30 June 2014

NSW Department of Planning & Infrastructure

University of Sydney Campus Improvement Program 2014-2020 – State Significant Development (SSD 6123) – Further submission and objection to EIS pursuant to community consultation meeting with Sydney University on 23 June 2014.

01 ENGINEERING - PROPOSED ENVELOPE PLAN

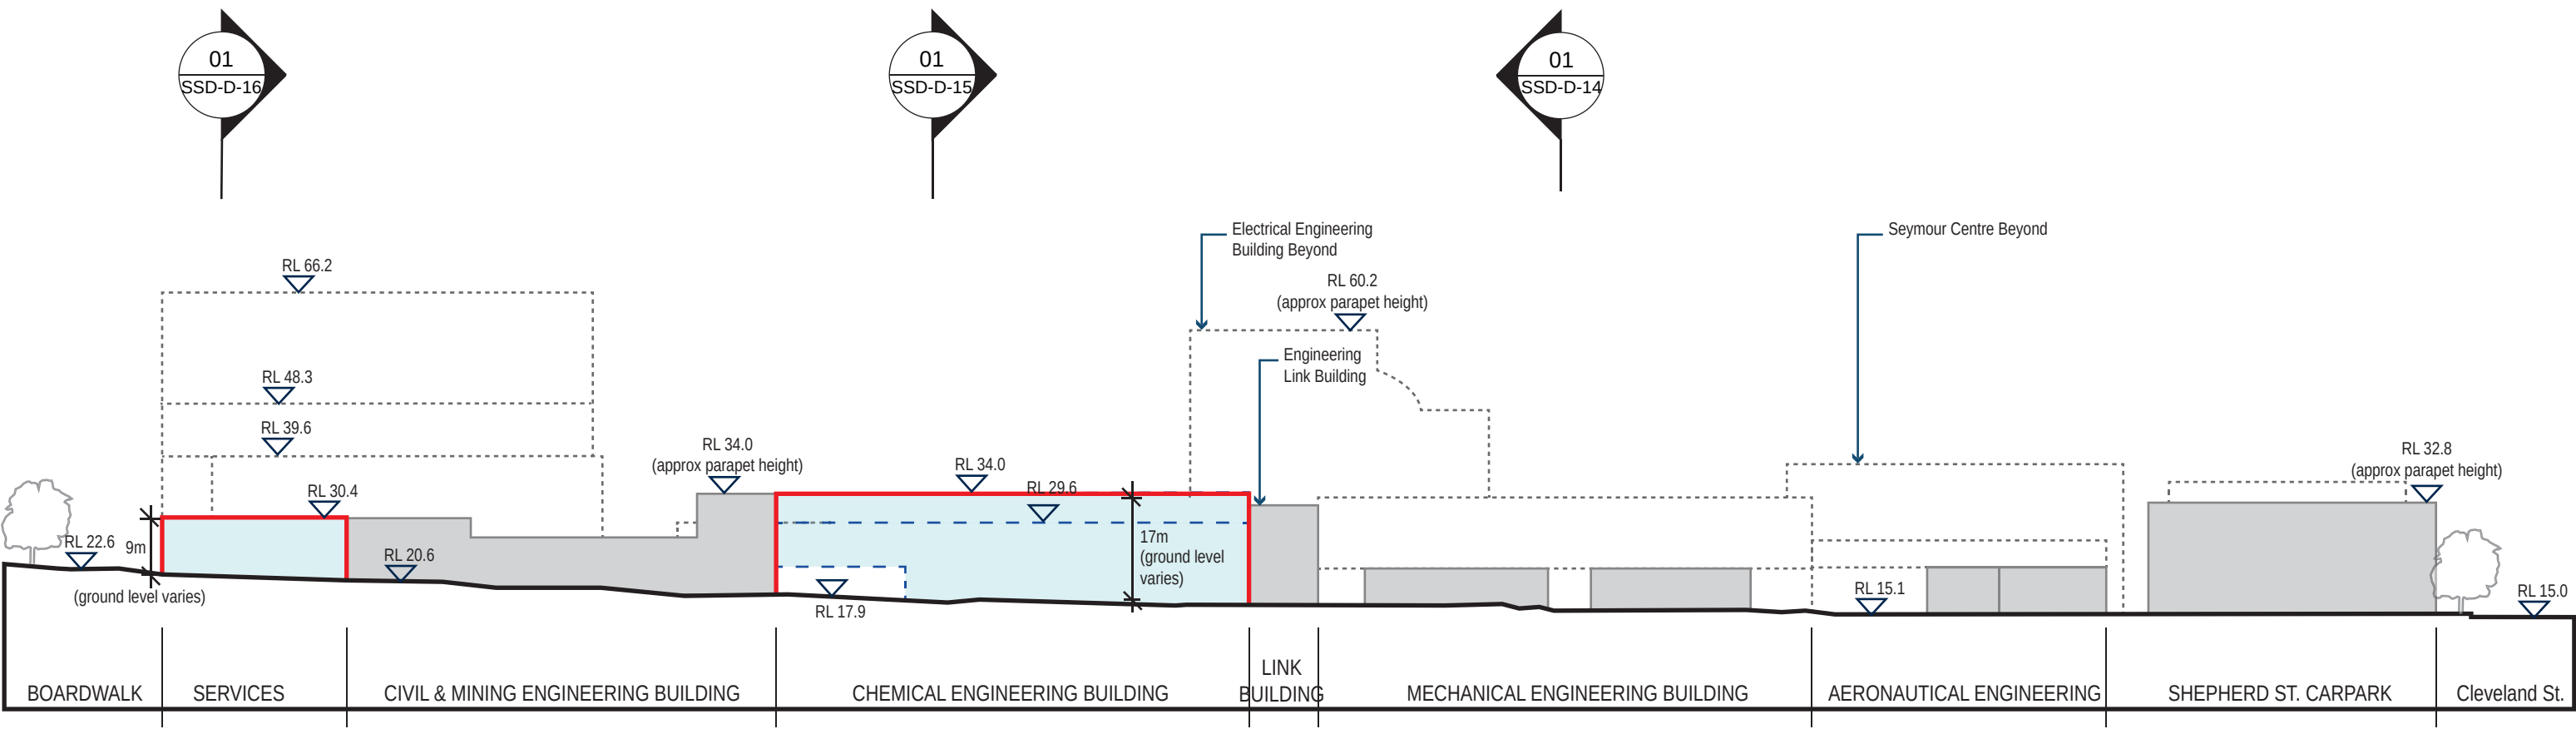
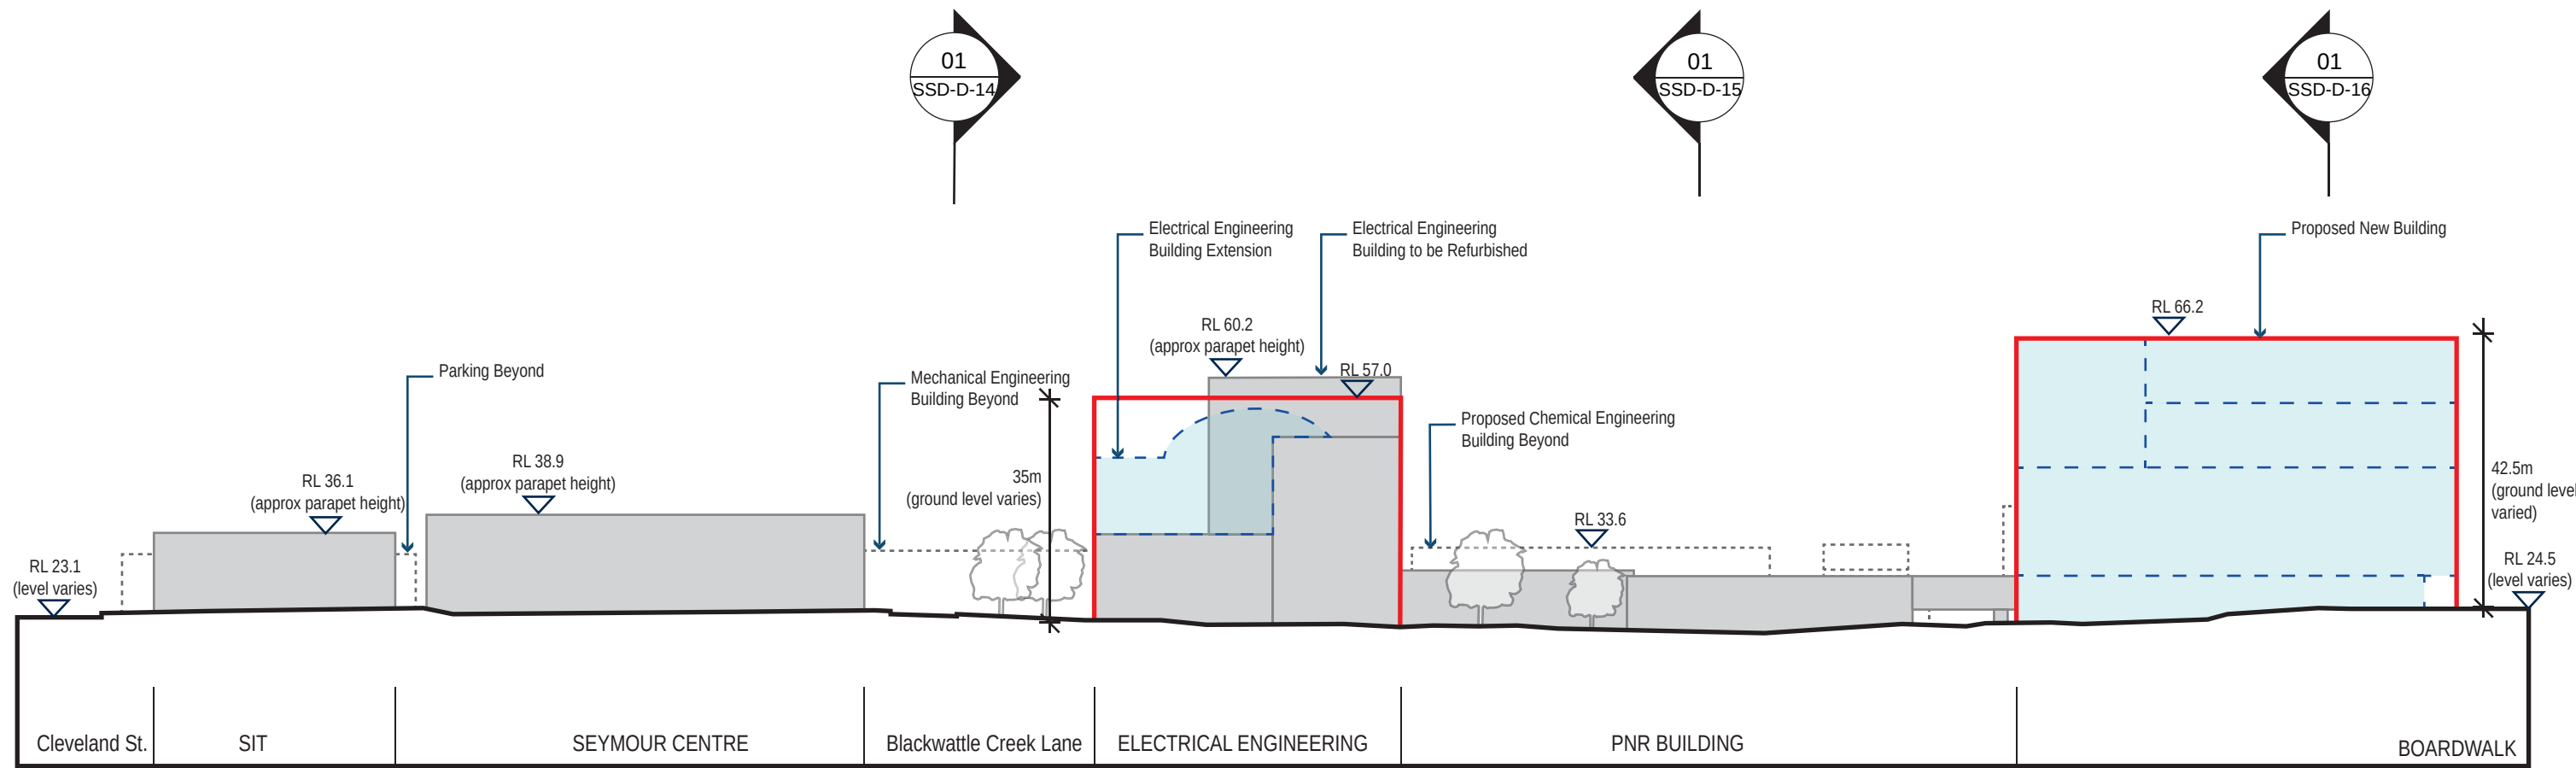
At the meeting the University indicated that it would modify its proposed development affecting the important eucalypt grove (tallowwood trees) on the University car park facing Shepherd Street near the corner of Calder Road.

The proposed modification would set back the new building along the frontage to Shepherd Street so as to preserve one row of trees (the row closest to the University's Shepherd Street boundary).

This modification does not meet the objections made by myself and many other people to the proposed destruction of the eucalypt grove. The following are the reasons:

- i. most of the trees would be lost (contrary to the impression given to the meeting the first row of trees proposed to be preserved is not a full row and contains only three of the nineteen trees in the grove);
- ii. mature tallwoods are large trees and the proposed set back appears inadequate to accommodate the first row of trees when fully grown (this can be seen from the canopy of the mature tree in the first row which extends well beyond the second row of trees and approaches the third);
- iii. the proposed three storey building would overlook and overshadow nearby terrace houses and shade the Engineers' Lawn from morning sun;
- iv. it would exacerbate the over-developed and ugly appearance of the University side of Shepherd Street; and
- v. it would frustrate the University's plans to open up its Shepherd Street frontage and make a connection between the street and Cadigal Green.

The constraints on the footprint and height of the proposed building, and therefore its floor space, have not been properly examined or admitted by the University and are such as to question its viability.

The destruction of the eucalypt grove on the car park at Shepherd Street near Calder Road, and the proposed building there, should not be approved. The University should put forward alternative proposals if the floor space is required.
